SSD 7382 UTS Central, Broadway Precinct

Detailed Response to Submissions – July 2016

Existing June 21st 8:30am Shadow

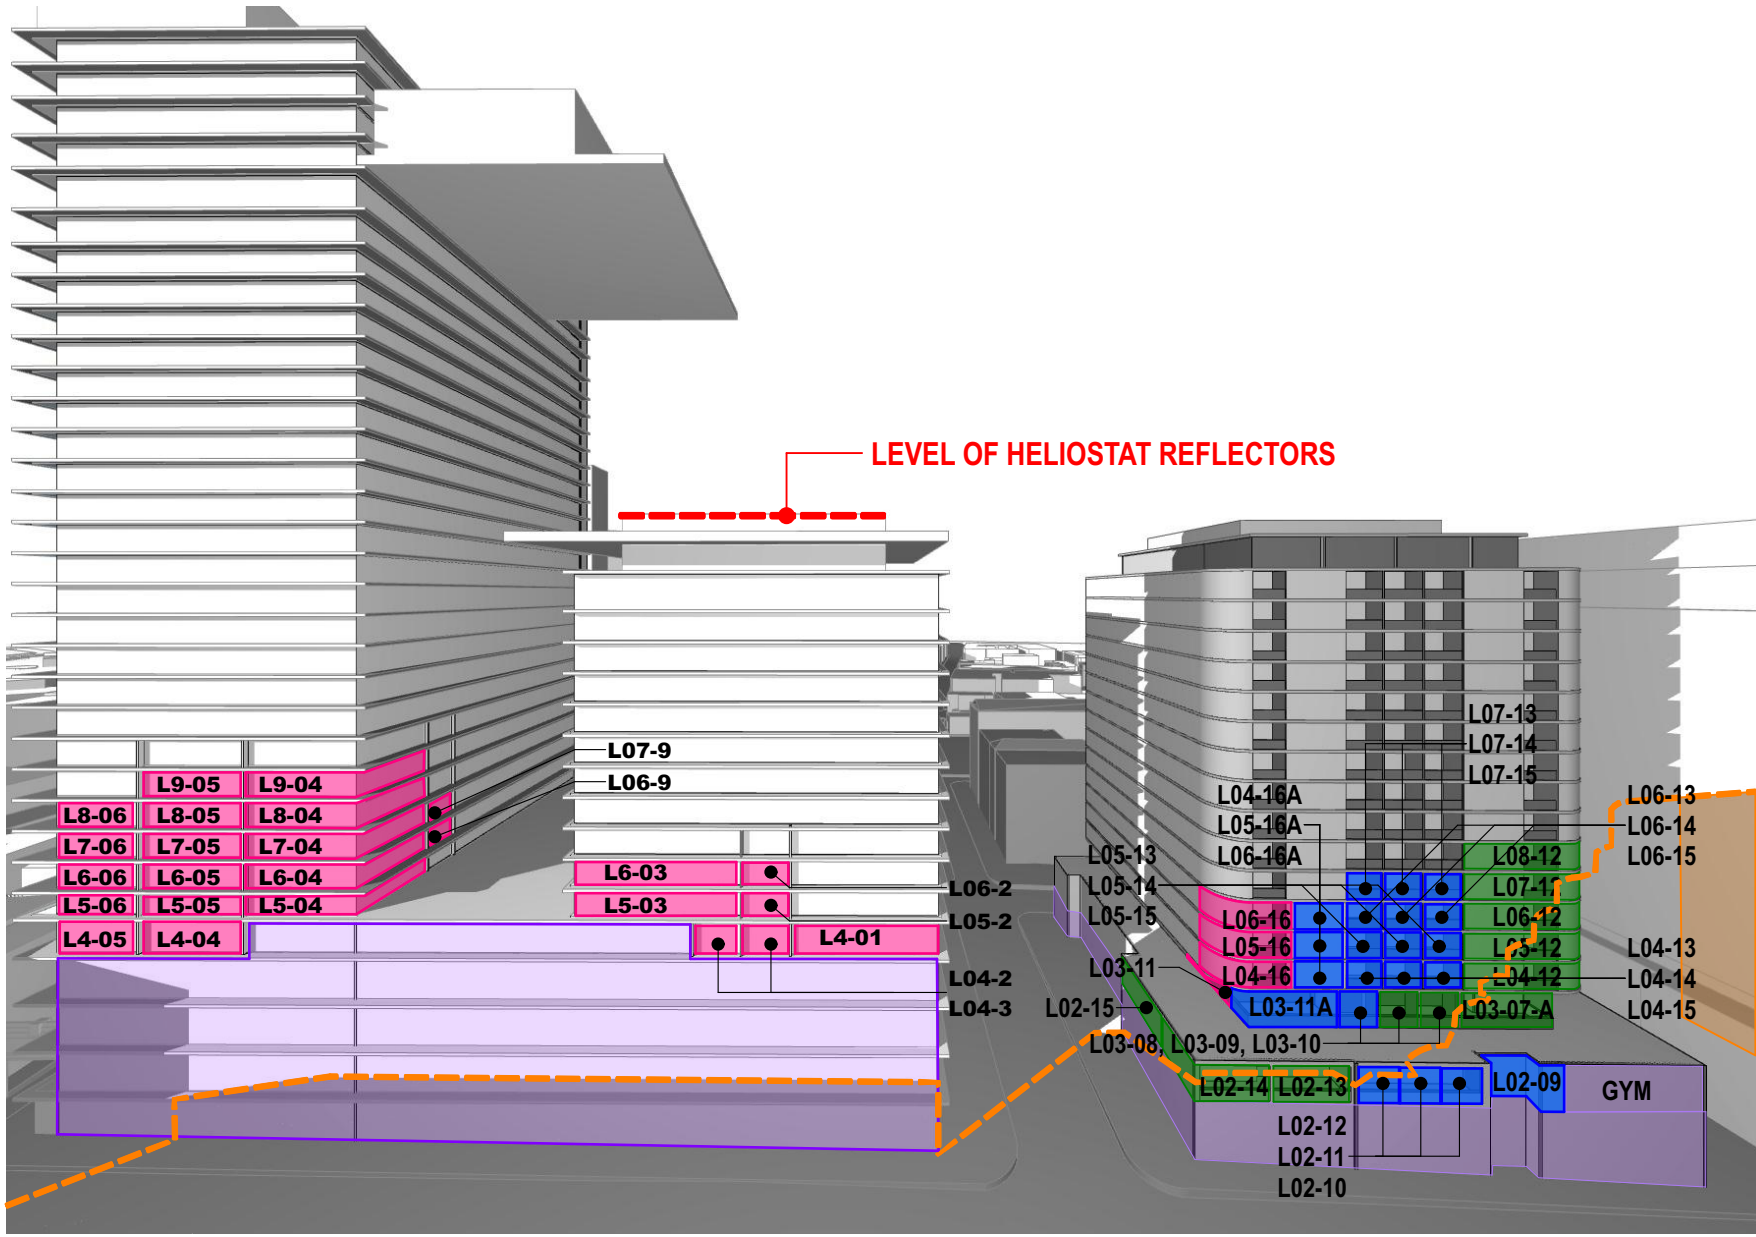
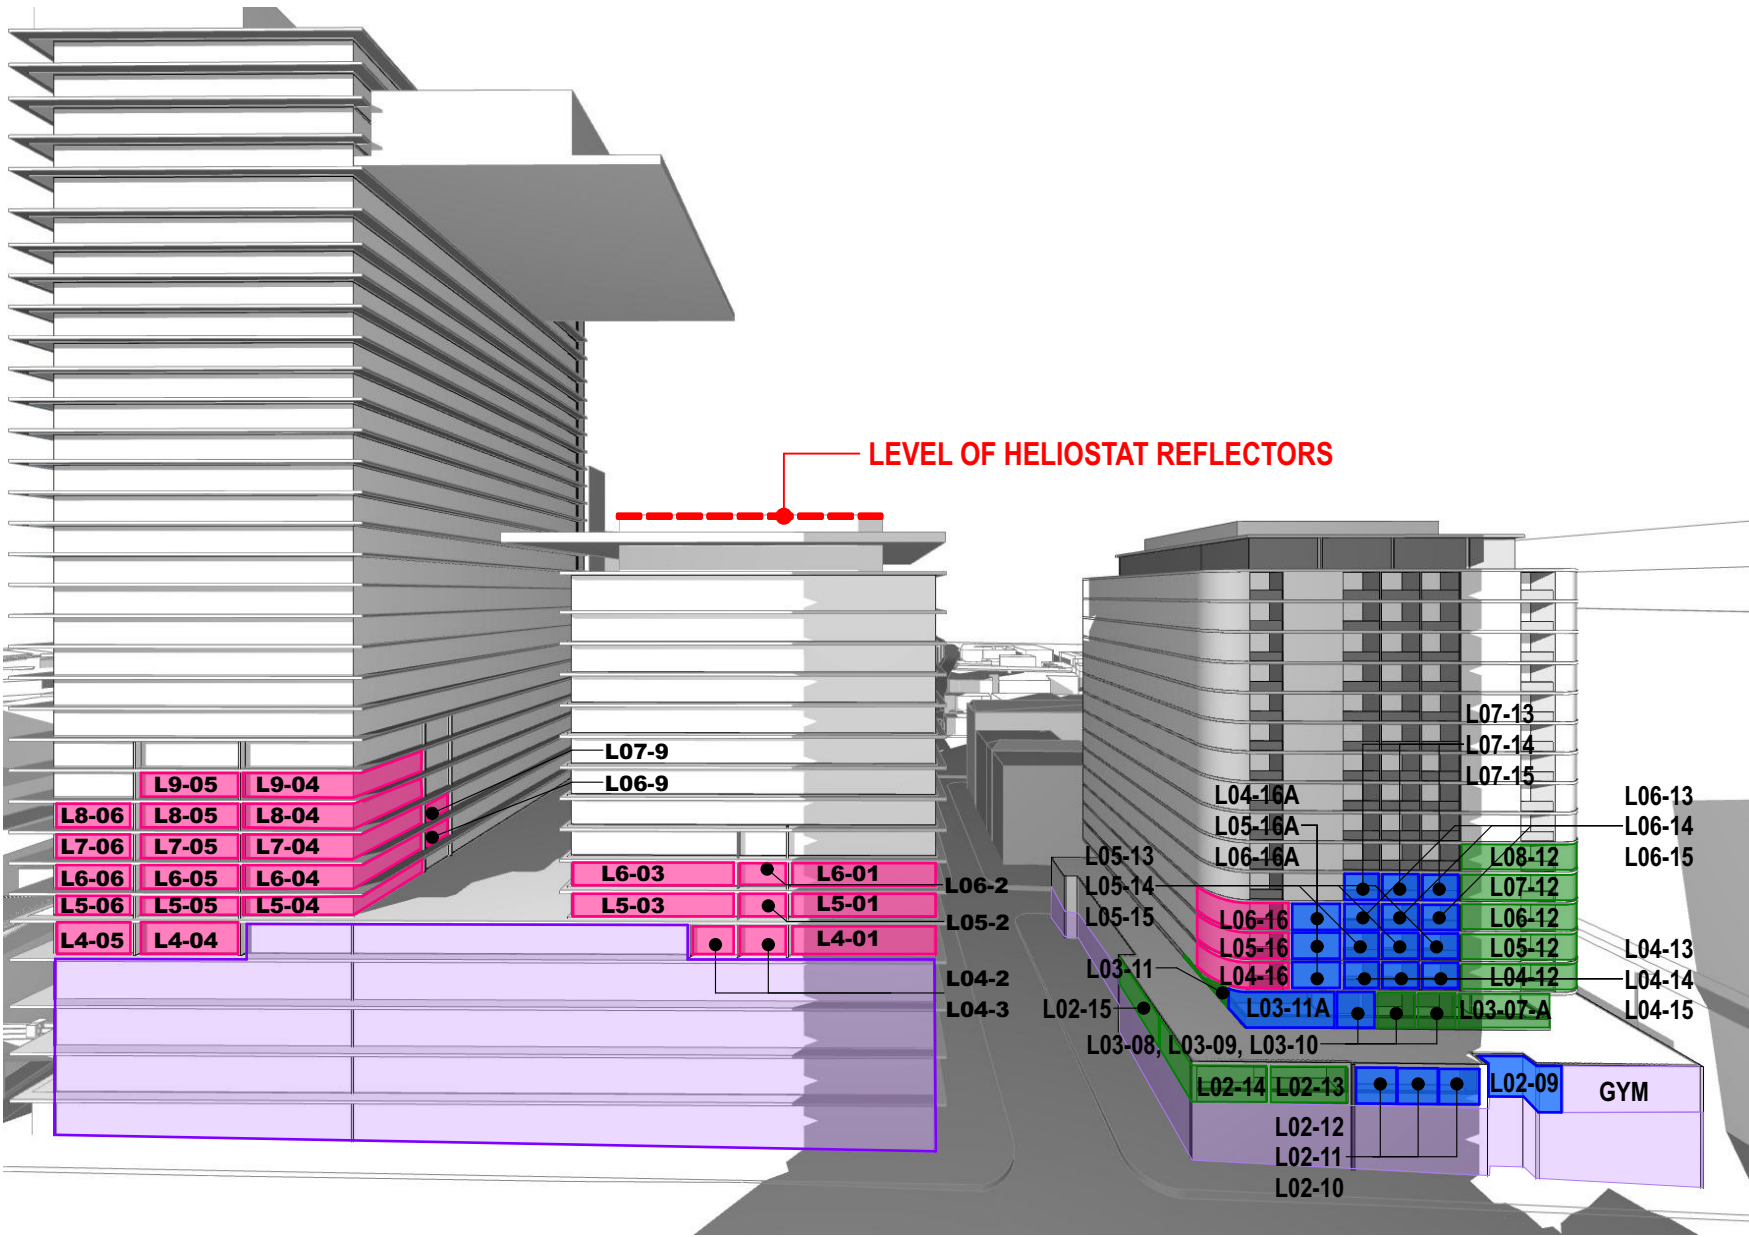
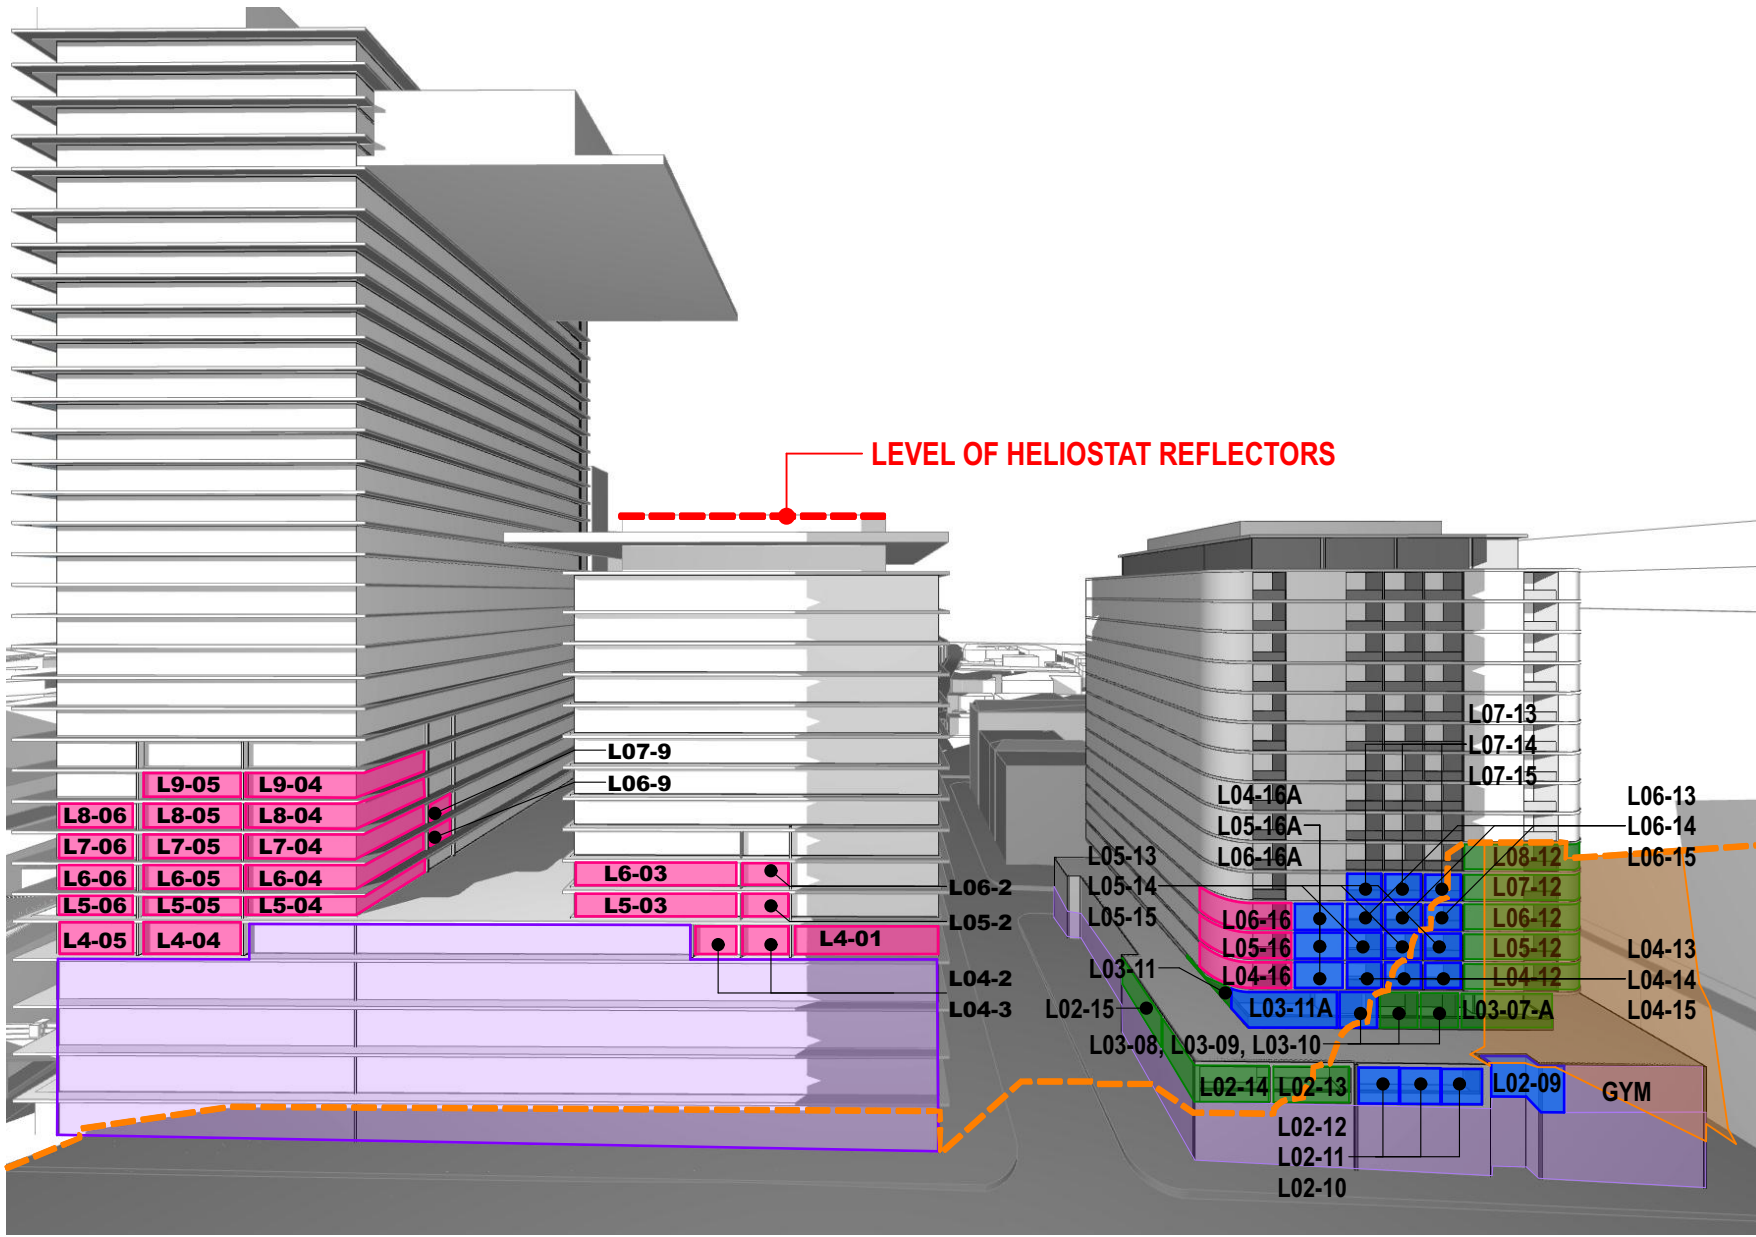
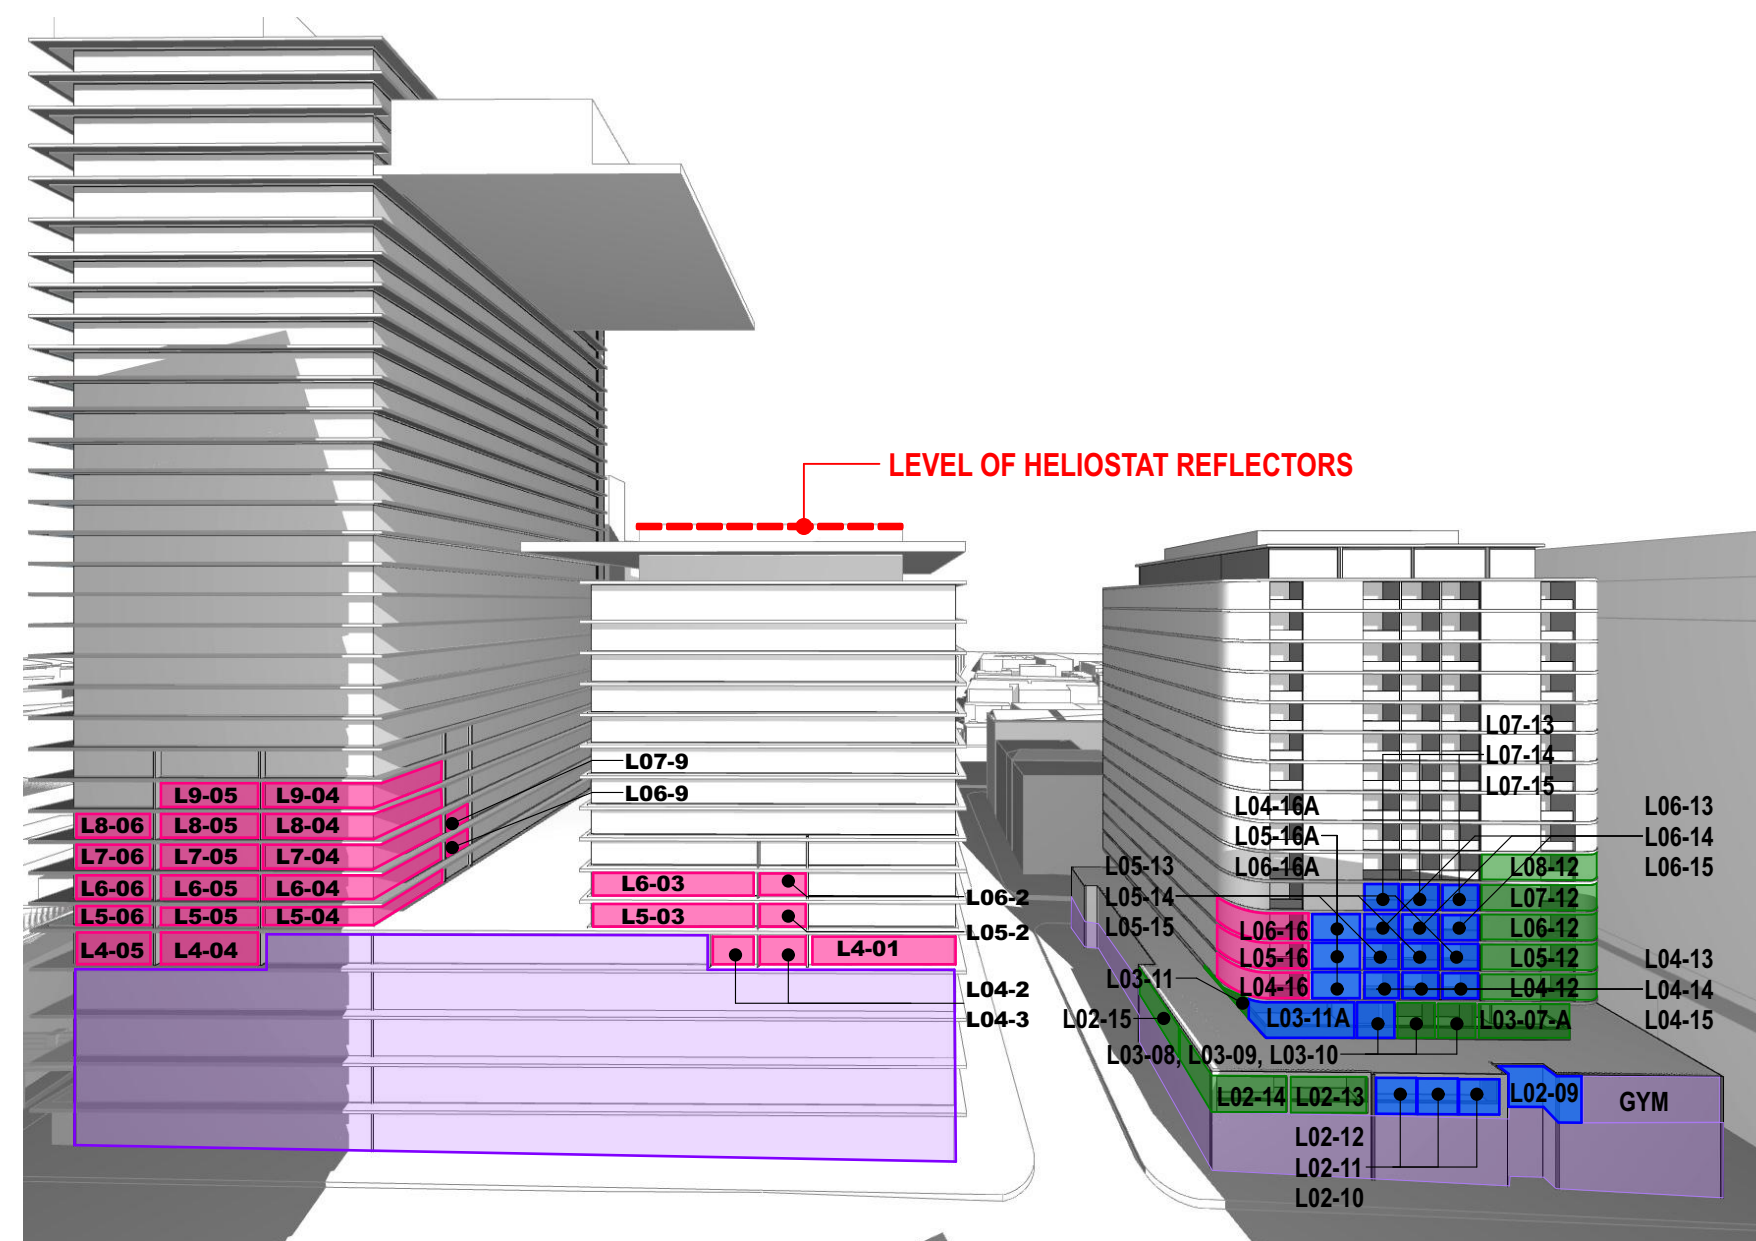
<p>Environmental and Residential Amenity</p> <p>5. The Department is concerned with the overshadowing impacts from the proposed building on the residential properties within Central Park and a further quantitate analysis of solar access to be retained and lost for all dwelling impacts by the proposal must be provided, including additional analysis of whether the proposal would impact on any heliostat solar collectors for building within Central Park.</p>	<ul style="list-style-type: none"> - FJMT and JBA have completed a detailed analysis on the overshadowing impact from the proposed building on the residential properties within Central Park as outlined within the main report. - The holistic assessment of the various amenity considerations for Block 1 demonstrates that notwithstanding the lower achievement of direct sunlight access, Block 1 will deliver a high level of residential amenity. - The proposed development is the same height as the lower tower of No. 1 Central Park and does not impact on the roof level of the lower tower where the reflectors are located or the roof level of the higher tower where the heliostat is located.

Solar & Daylight Access <p>In order to demonstrate that the proposed development is able to comply with Objective 3B-2 of the Apartment Design Guide and Section 4.2.3.1 of the Sydney Development Control Plan 2012, a solar analysis should be provided of the surrounding buildings and rooftop on which the heliostat solar collectors are located. A daylight report and LUX level map of affected apartments should also be submitted.</p>		<ul style="list-style-type: none"> - Detailed elevational shadow diagrams for Central Park (One Central Park and Block 1) have been prepared by FJMT (Attachment B) for June 21 (7.30am to 3pm) illustrating: <ul style="list-style-type: none"> - Shadows Cast by the modified Concept Plan (MOD 5 envelope) - Shadows cast by UTS Central SSDA. - Further, the existing building shadows cast over Central Park have been previously prepared and are also submitted with this report. - The proposal has been reviewed against the following: <ul style="list-style-type: none"> - <i>Objective 3B-2 of the Apartment Design Guide.</i> - <i>Section 4.2.3.1 of the Sydney Development Control Plan 2012.</i> - As outlined within the main report, the holistic assessment of the various amenity considerations for Block 1 demonstrates that notwithstanding the lower achievement of direct sunlight access, Block 1 will deliver a high level of residential amenity.
